# Ploughley Road

AMBROSDEN

Design and Access Statement Addendum March 2023

This document has been prepared as an addendum to the Design and Access Statement submitted for the outline application for 120 dwellings at Ploughley Road, Ambrosden, on behalf of Bellway Homes.

drawing title
Plan EDP 1: Tree Protection Plan (Overview)

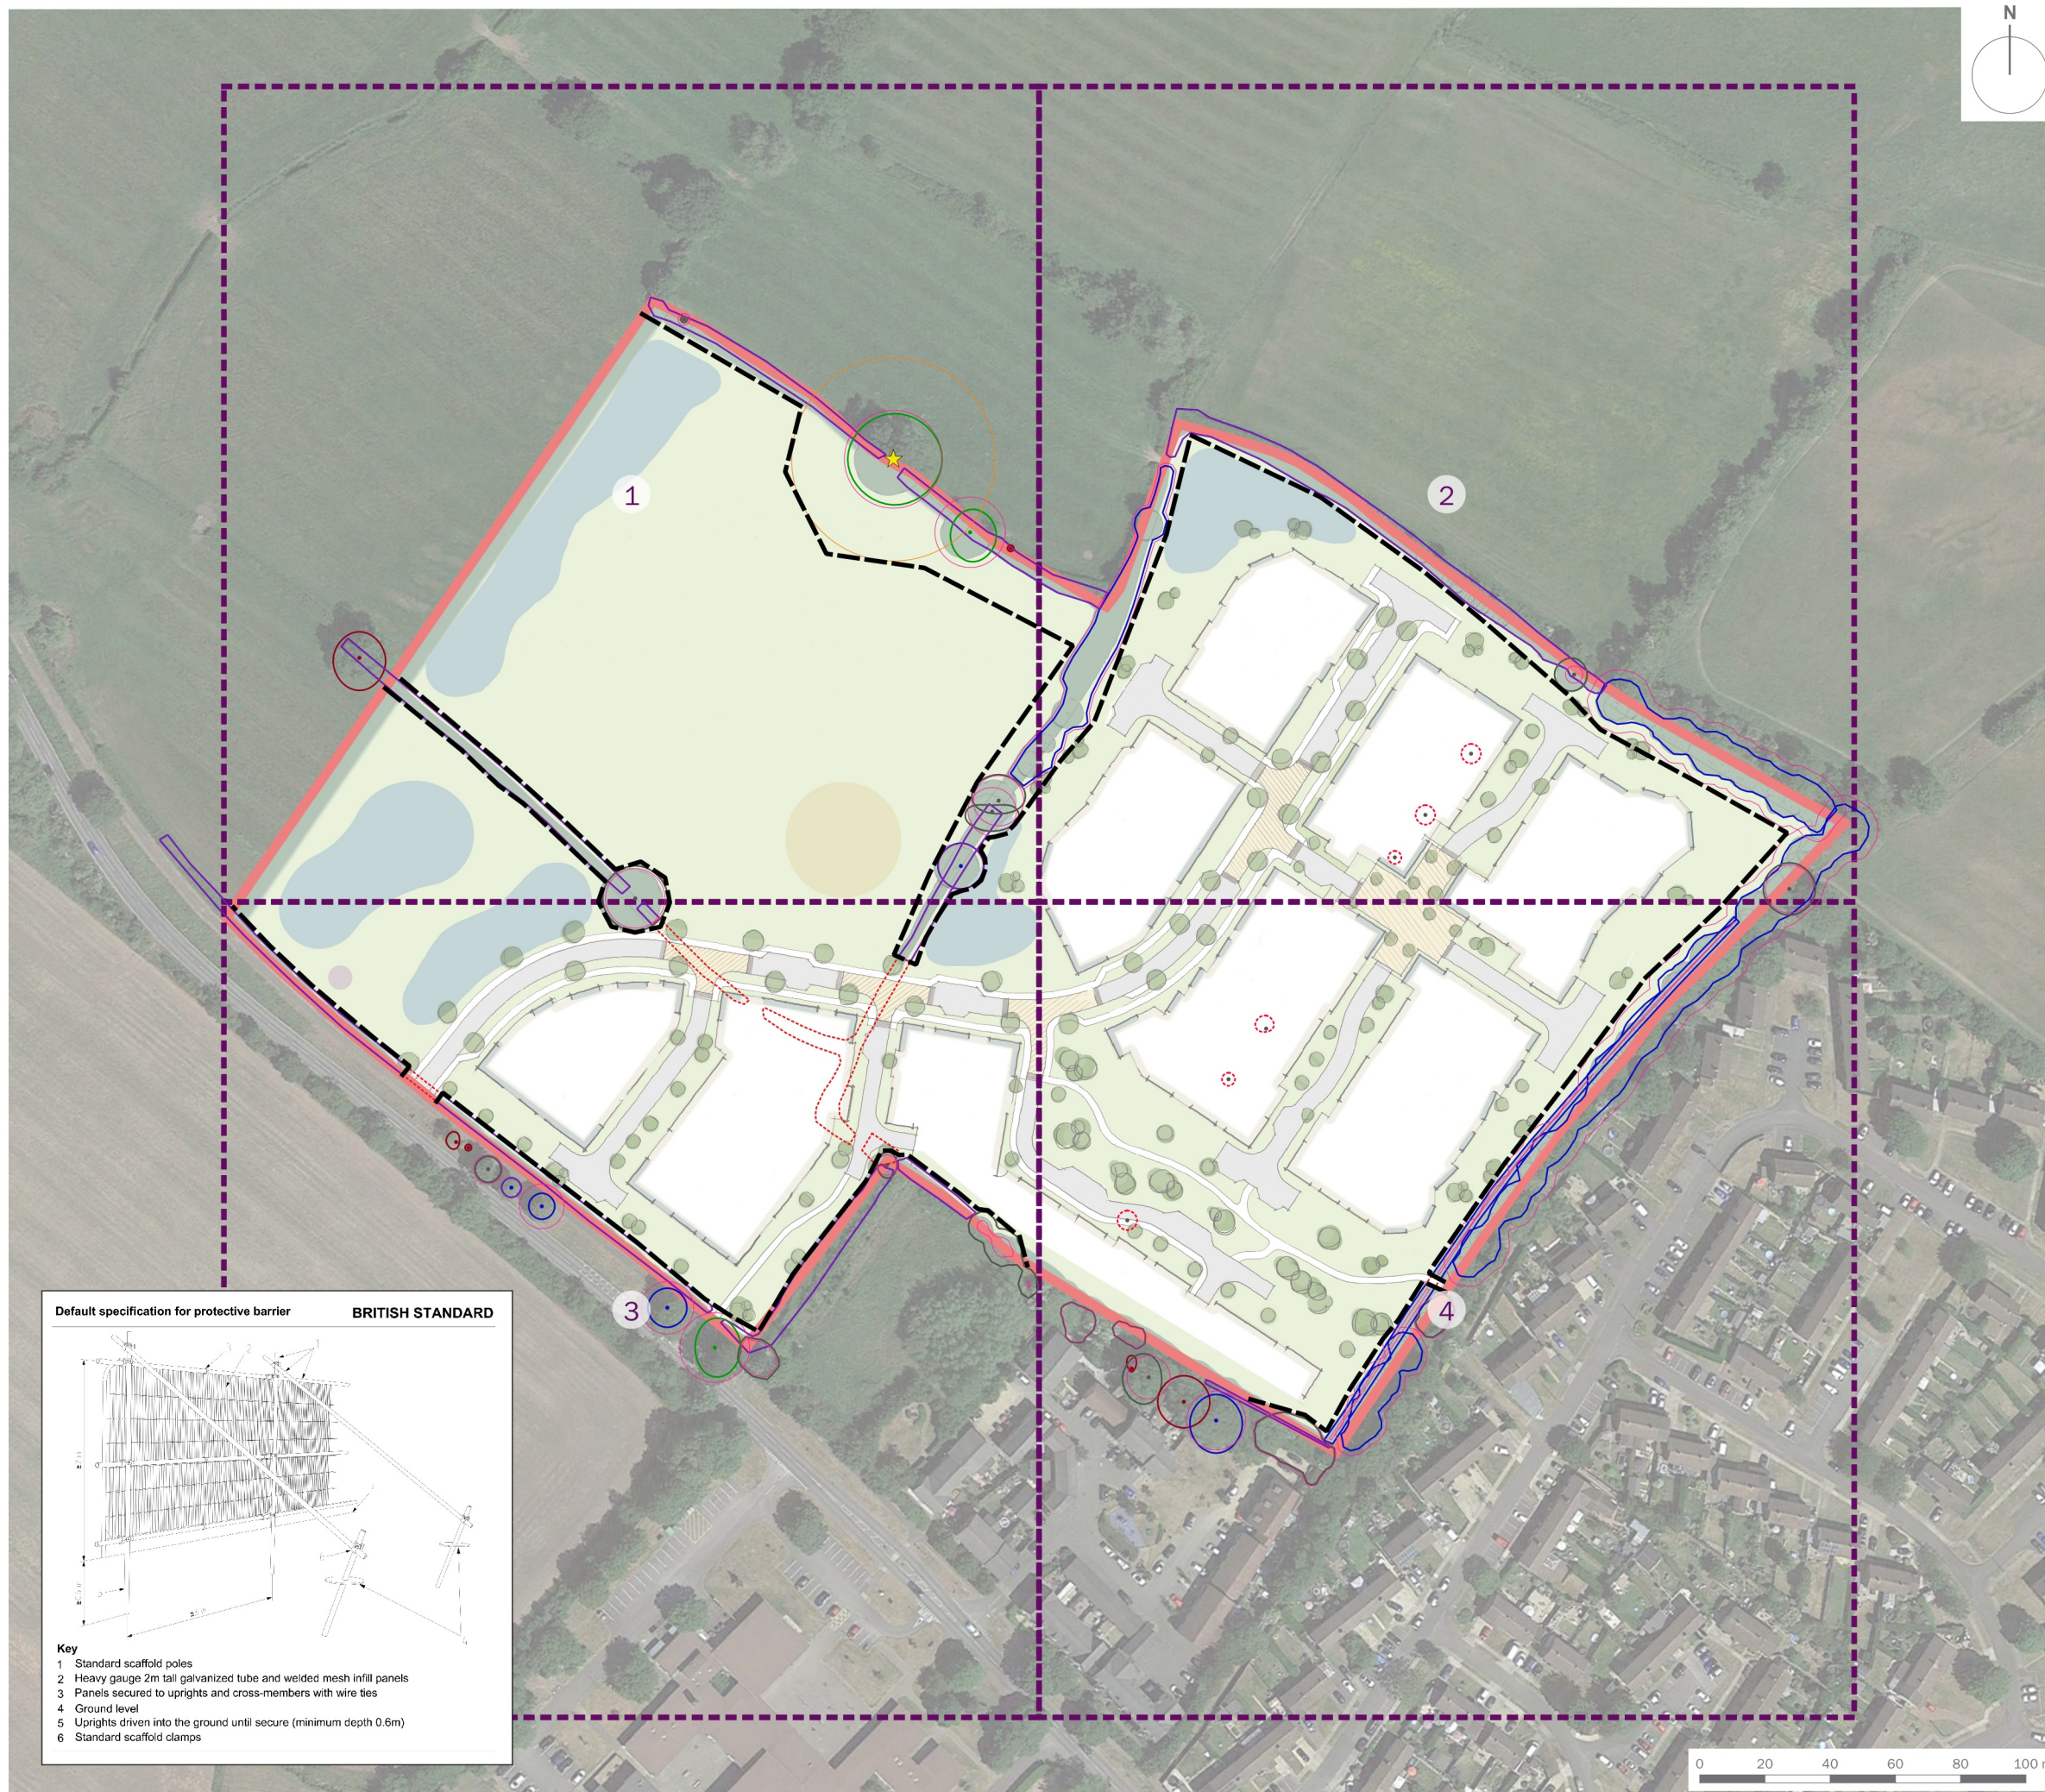
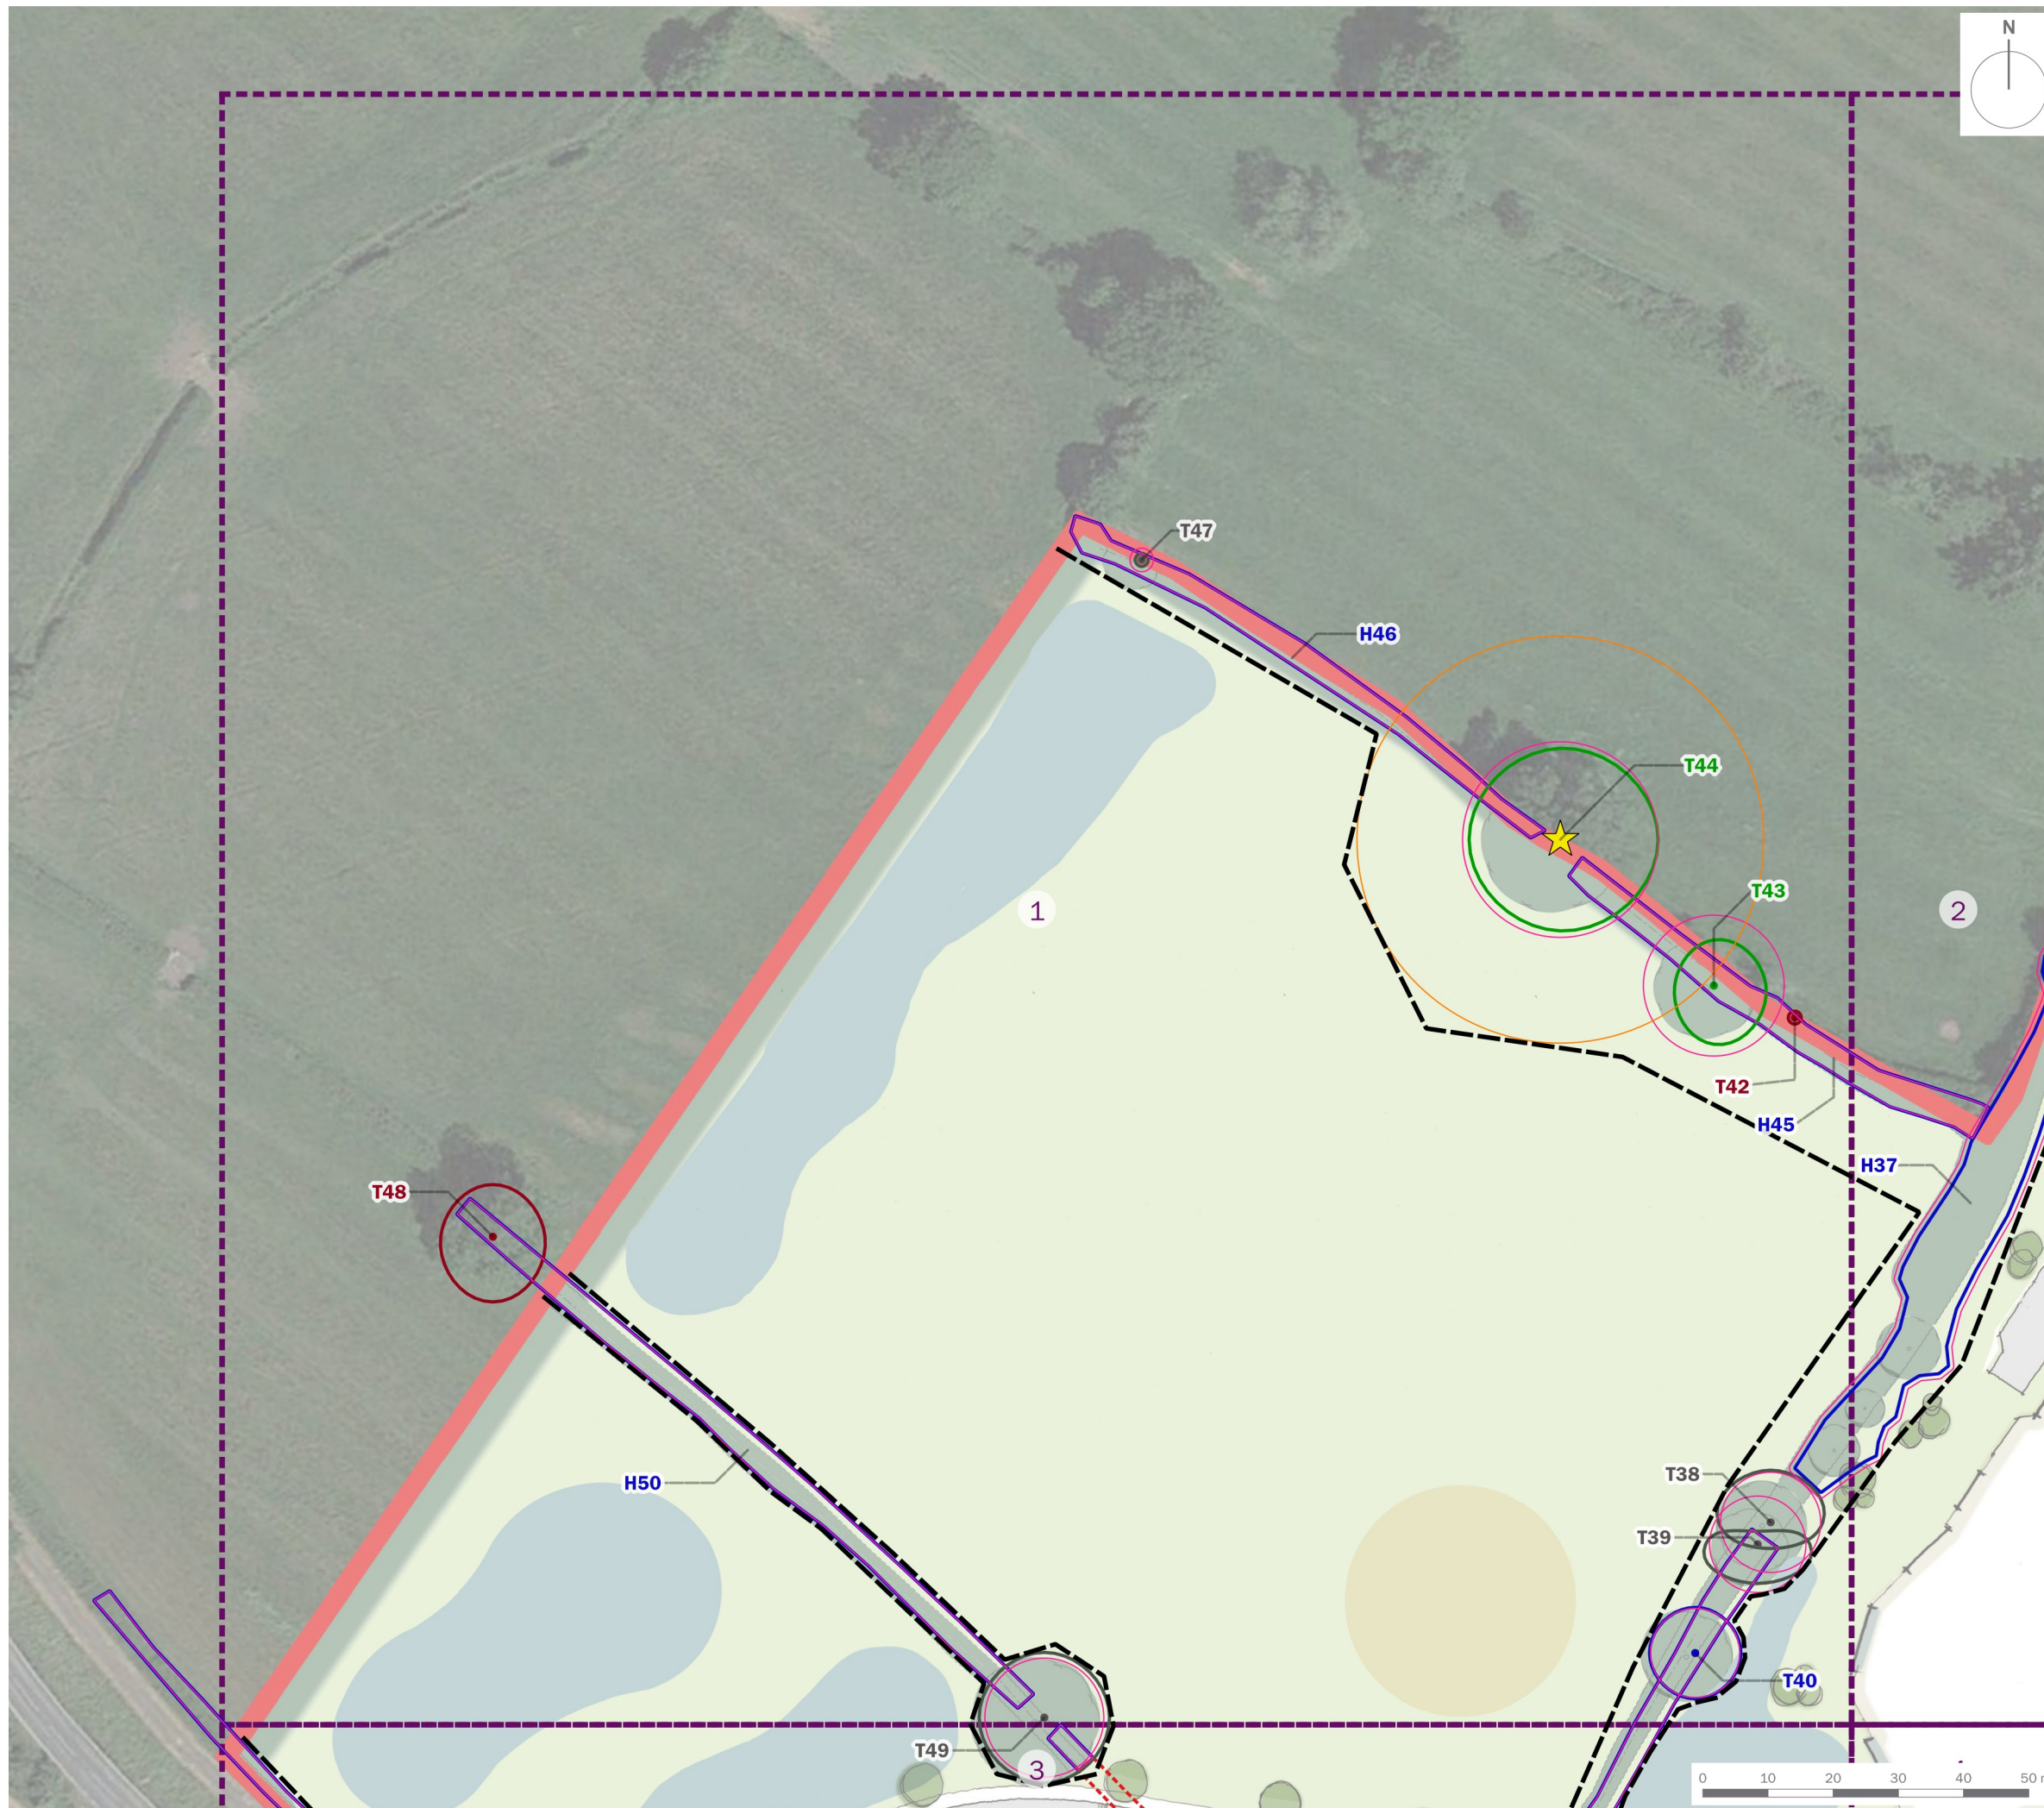
The adjacent image shows an extract of the tree protection plan, (page 12 of Arboricultural Addendum Statement) overlaid over the above framework plan to indicate the Arboricultural impact of the pedestrian link in this location.

The pedestrian link as currently proposed in this location would result in the partial loss of a category C tree G25 as pictured.

In order to mitigate the impact of the pedestrian access on the existing boundary vegetation as described on Page 3, it is proposed that the pedestrian access point (C) is relocated approximately 15 metres north, as shown in the adjacent extract of the updated Framework Plan.

The amended access point will be positioned outside of the RPA's and will still provide direct access to the existing bridleyway leading on to West Hawthorne Road.
